Subject: FW: Planning Consultation on: R/147/21/PL

Application ref: R/147/21/PL

Description: Two secure cycle stores to south side of existing garage block, 2m timber fence & soft landscaping around the perimeter. This site is in CIL Zone 4 (Zero Rated) as other development.

Location: Land to the south of garage compound Sutherland Close Rustington

GROUND FLOOR PLAN 1:100 @ A3 / 1:50 @ A1

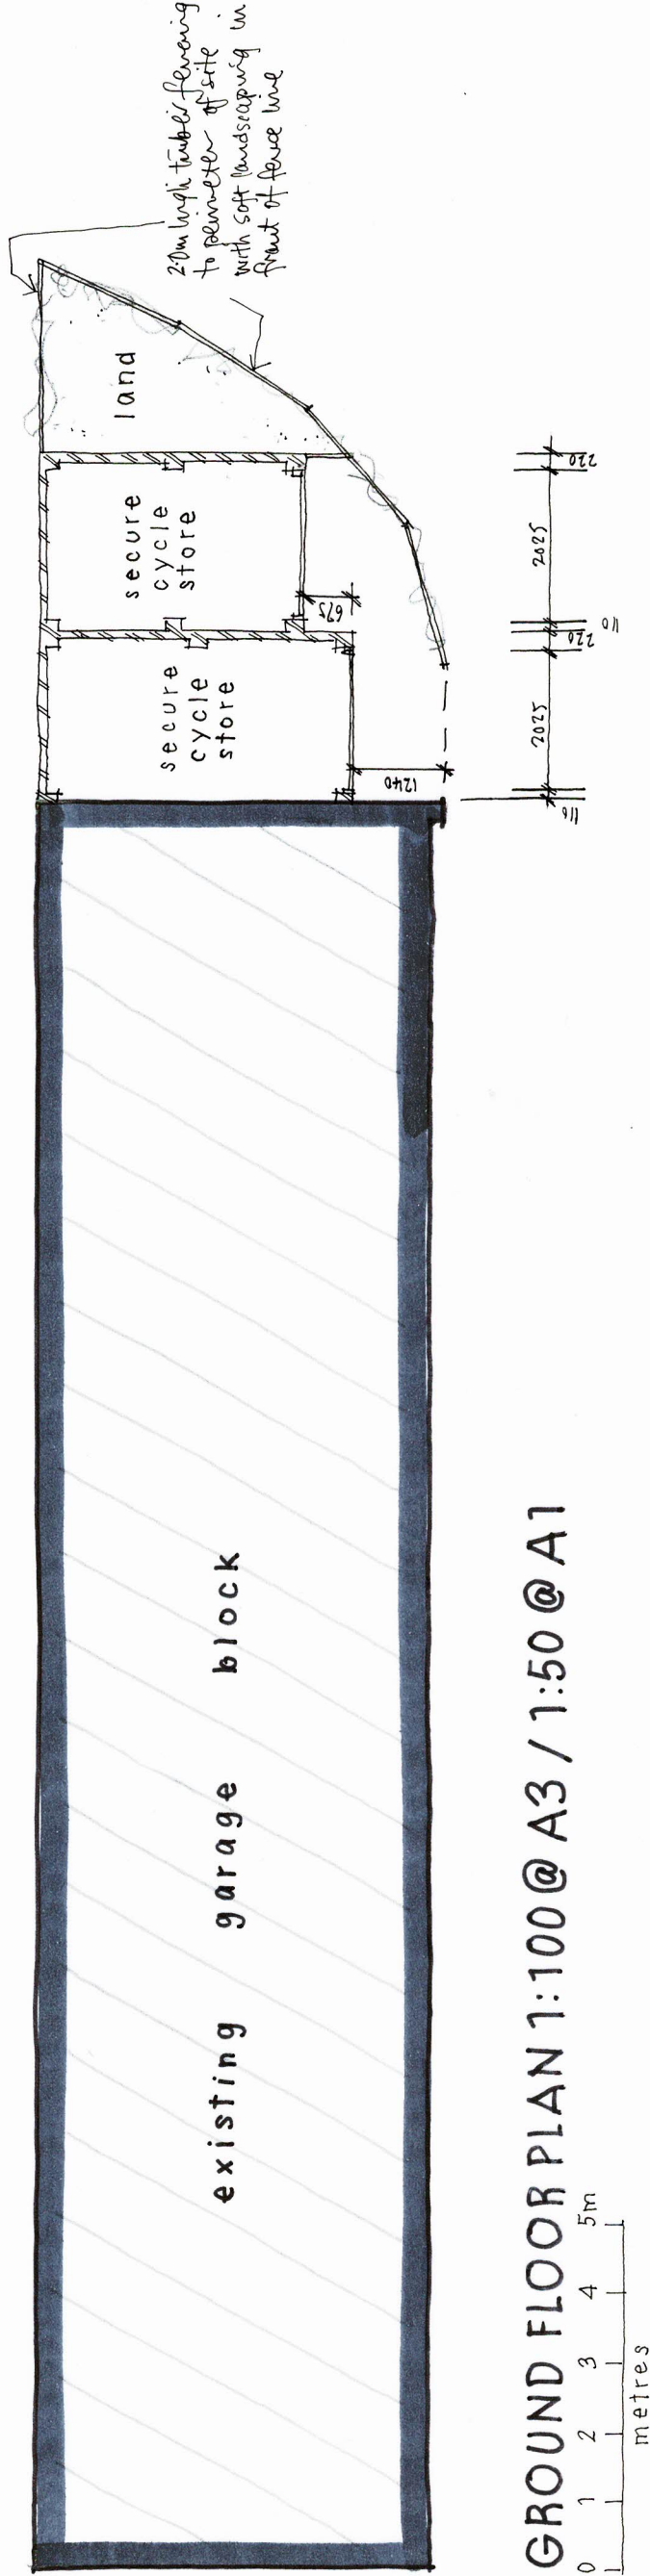
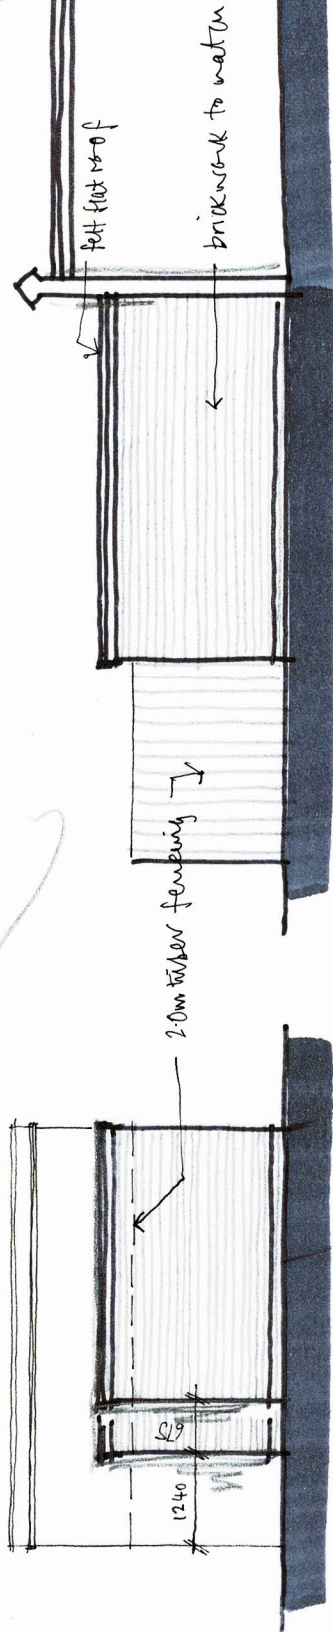
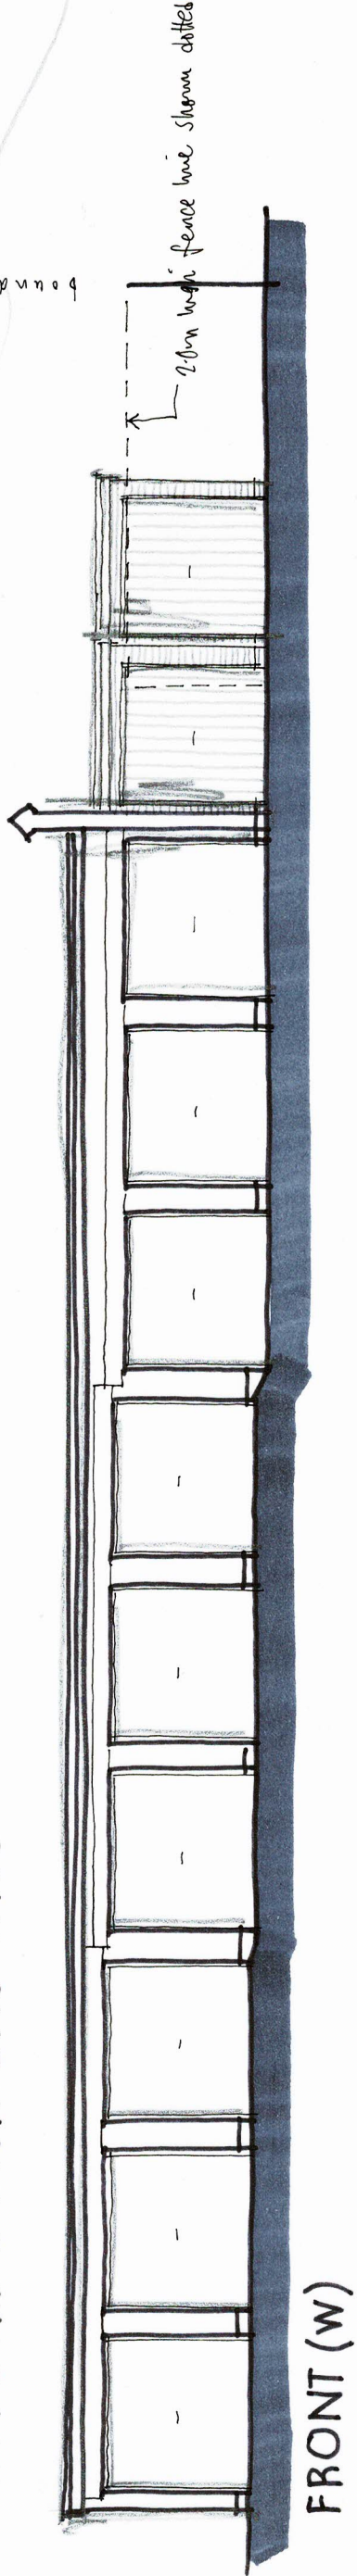
The NPPF para 124/127 relate to good design principles which equally apply to small infill and replacement development. The indicative **site layout plans has made reference to landscaping to soften the appearance of the fence, however this detail has not been provided.**

All proposed planting should be considered and its connection for biodiversity and habitat explored, with a biodiversity net gain following development. Plants specified need to be suitable for location and not block Sutherland Close visibility to the adjacent junction. Plants specified should be at a size which allow instant impact, but which will establish and mature as the site develops.

This detail would be required to be submitted in plan form detailing species choice, actual plant quantities, planting densities and size at time of planting.
